Re: Juan Tabo Hills Request for CLOMR Response to Comments (Project # 1005278)

Below, please see our response to your comments dated April 8, 2015 for our request for CLOMR for Juan Tabo Hills Estates.

**GRADING & DRAINAGE PLAN**

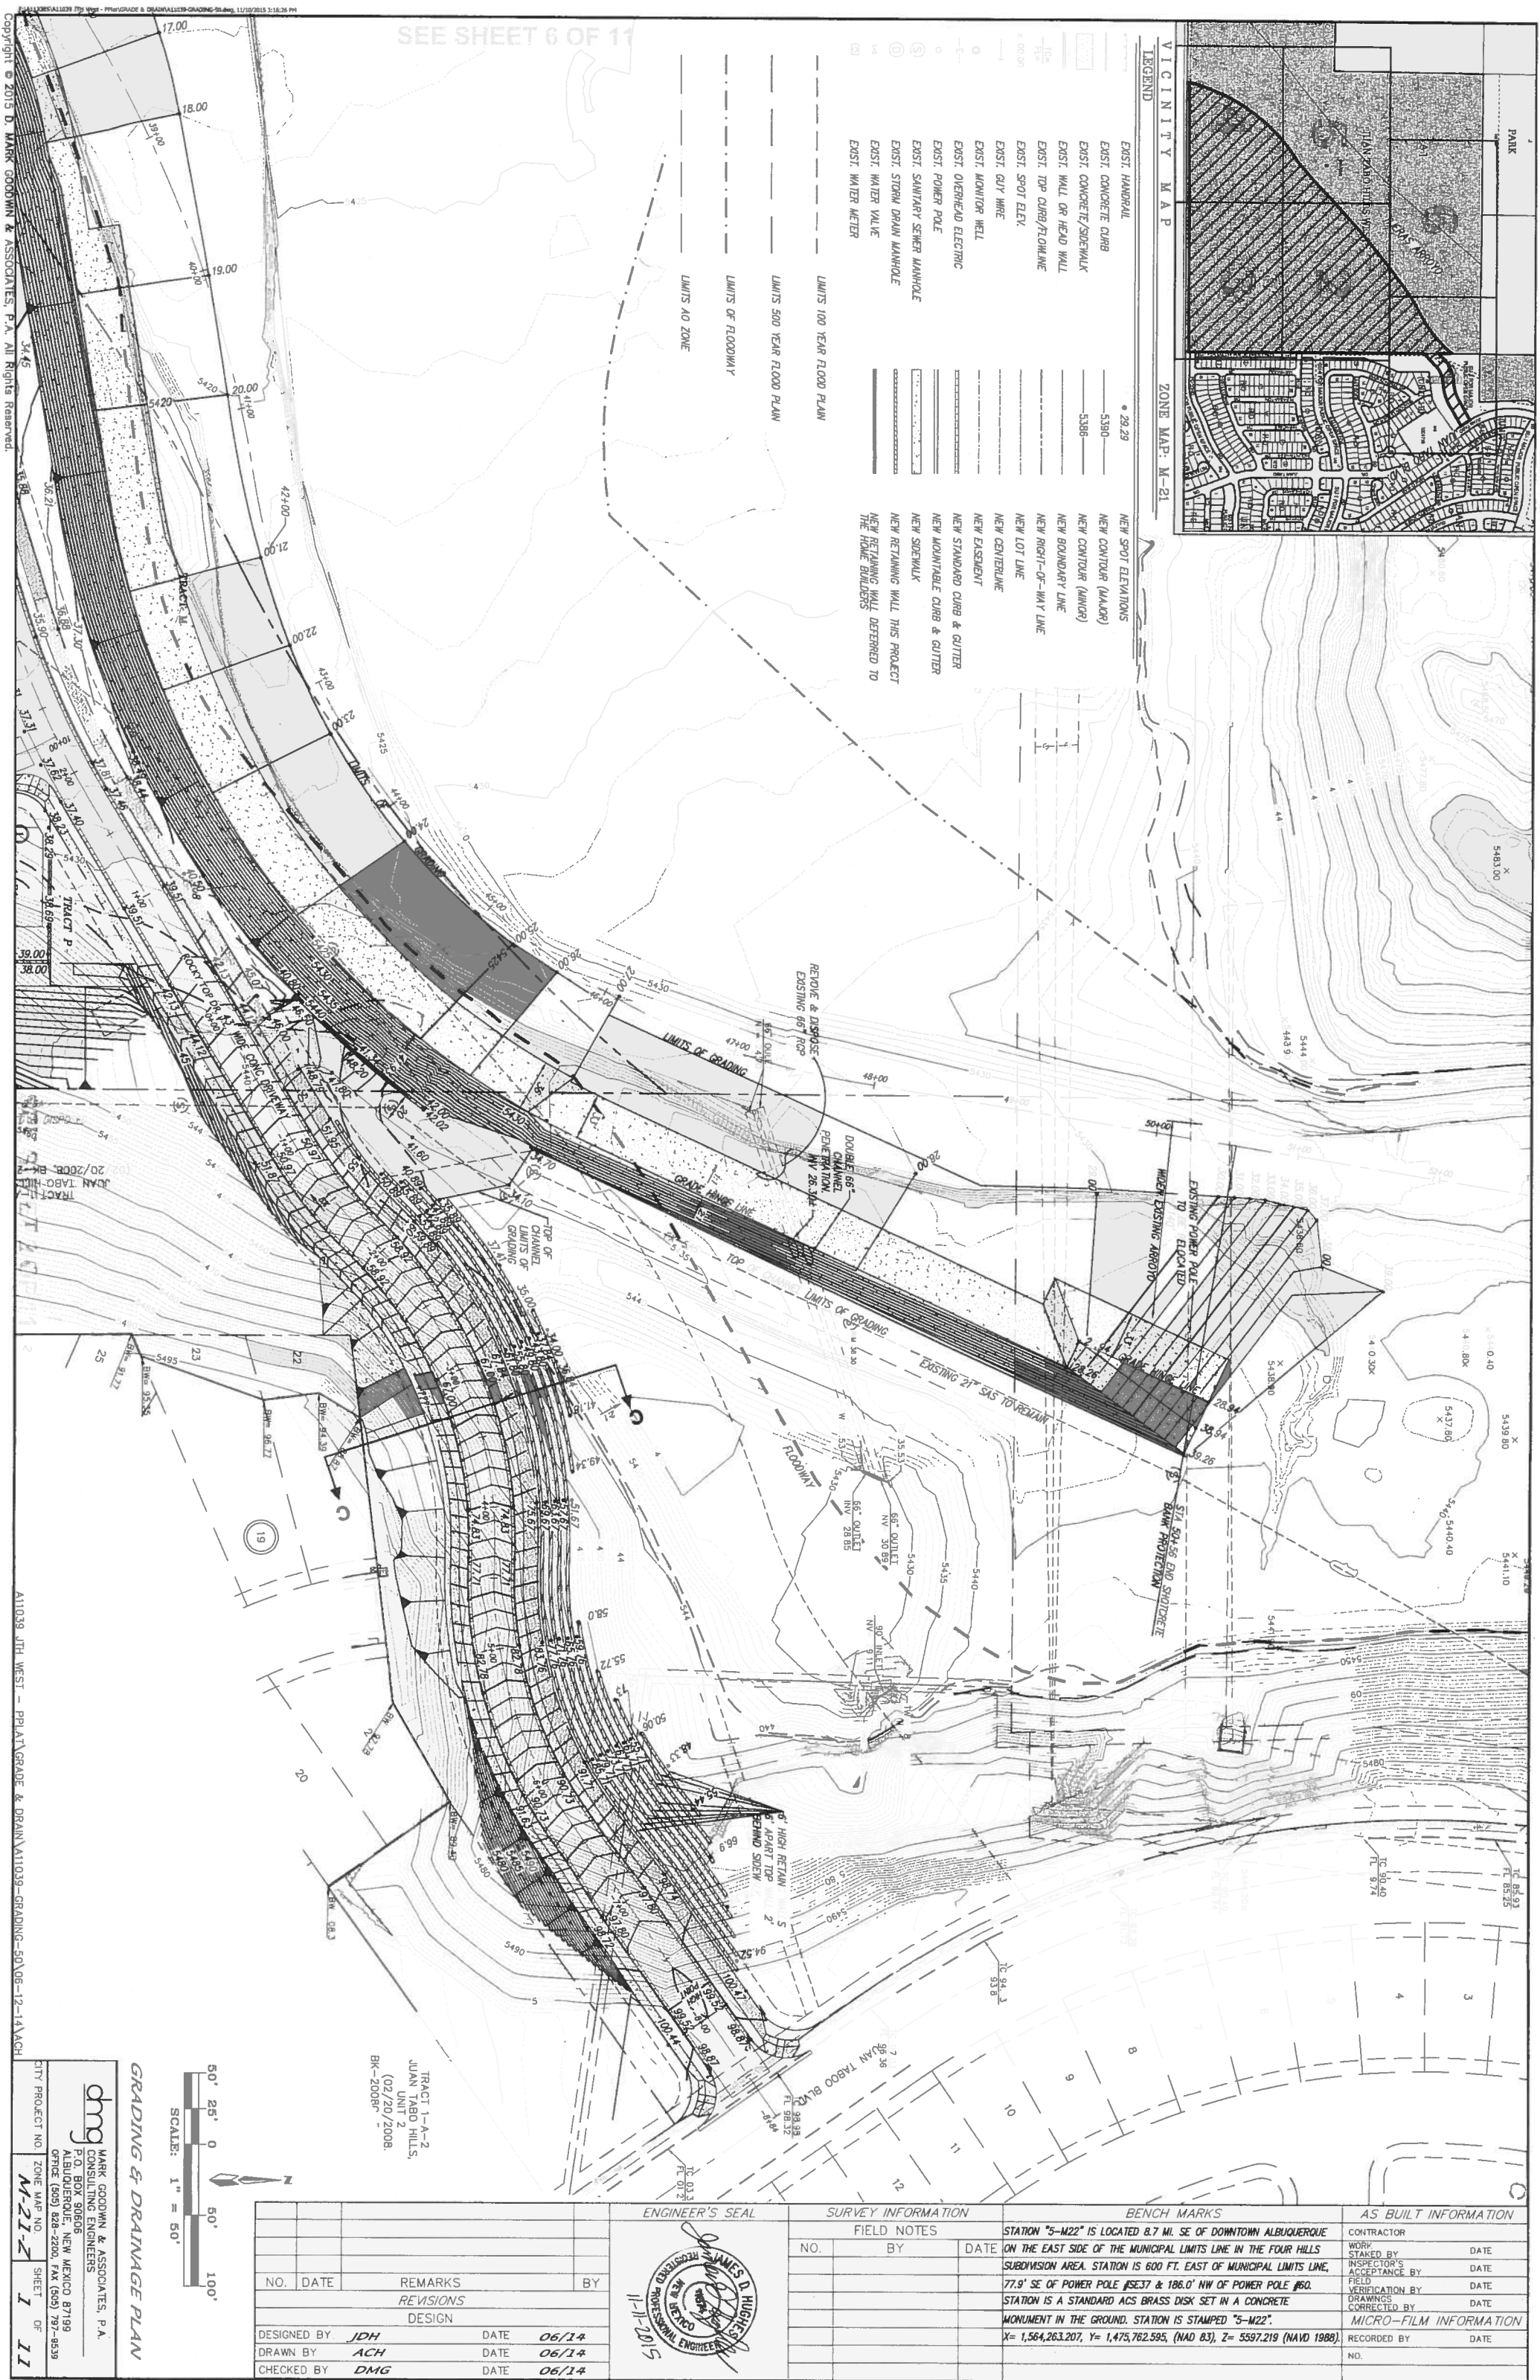
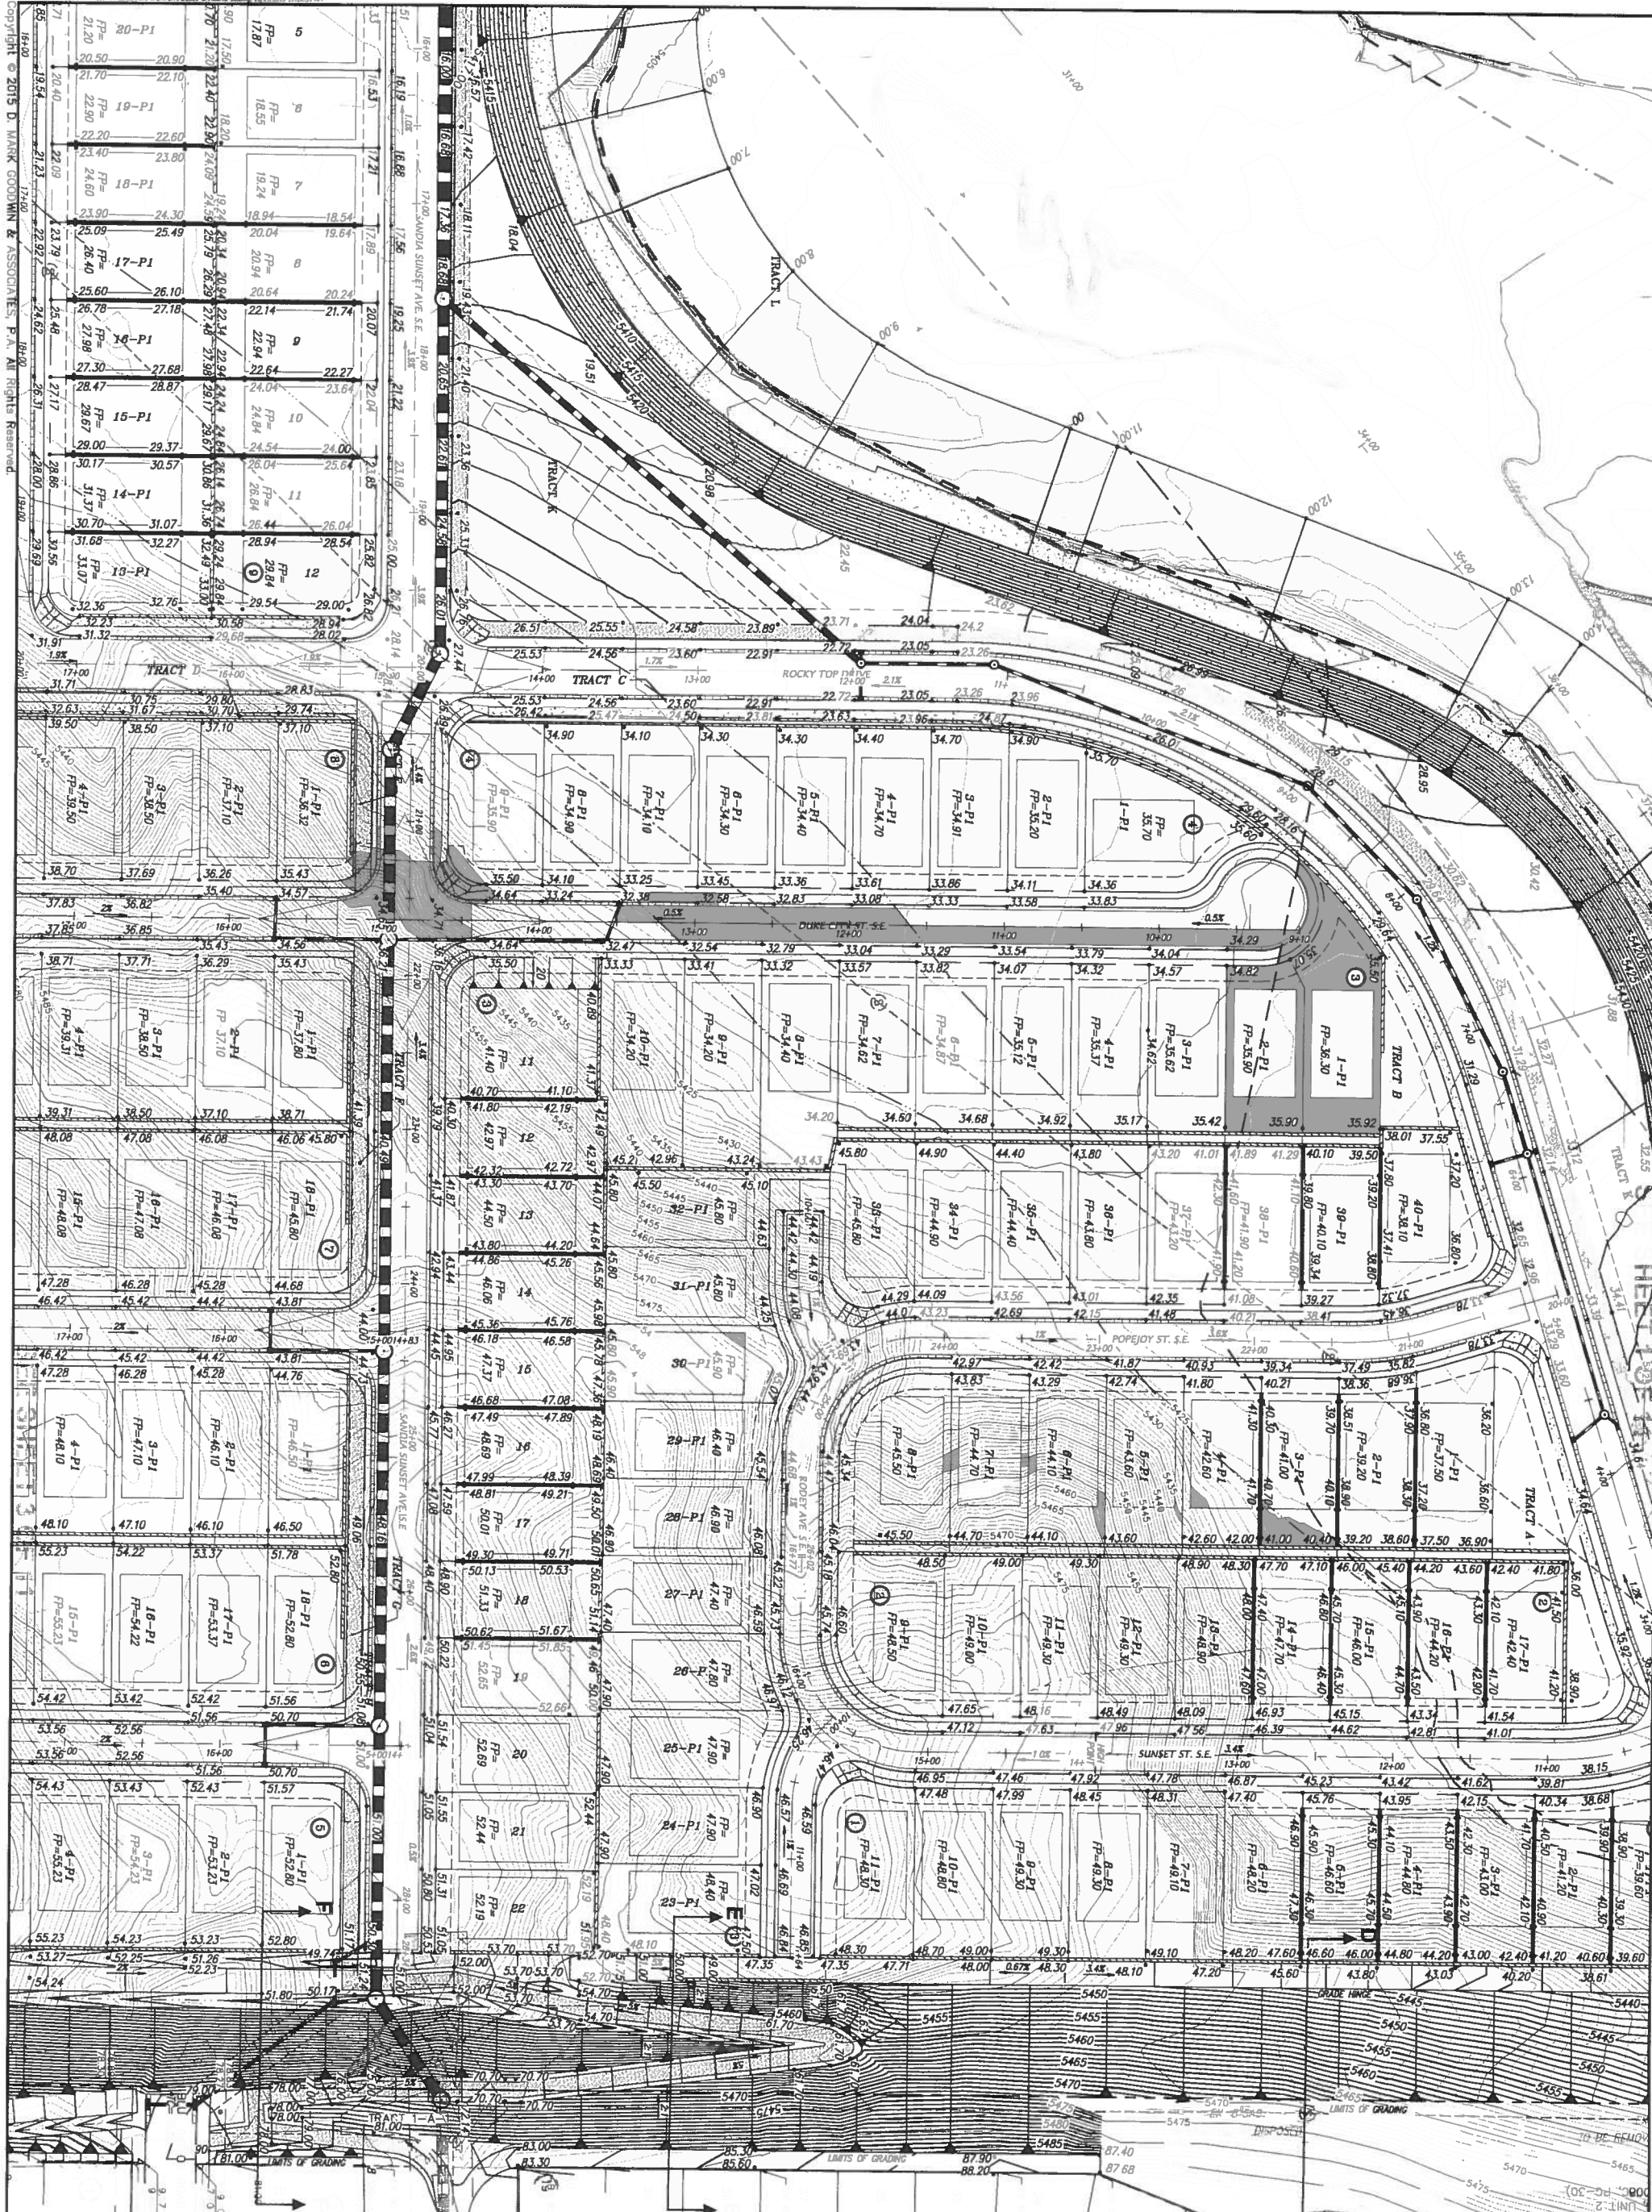
2. A brief review of the grading plan revealed that it was difficult to determine the amount of fill because existing contours were not labeled and spot elevations were not provided. **The revised Grading Plan Contours are now labeled.**

3. The grading plan should show the flood zone(s) and floodway where appropriate. **Flood Zones are now on Grading Plan.**
4. Provide the Annexation agreement. This area is still shown in the County. **Annexation documentation has been added to appendix.**
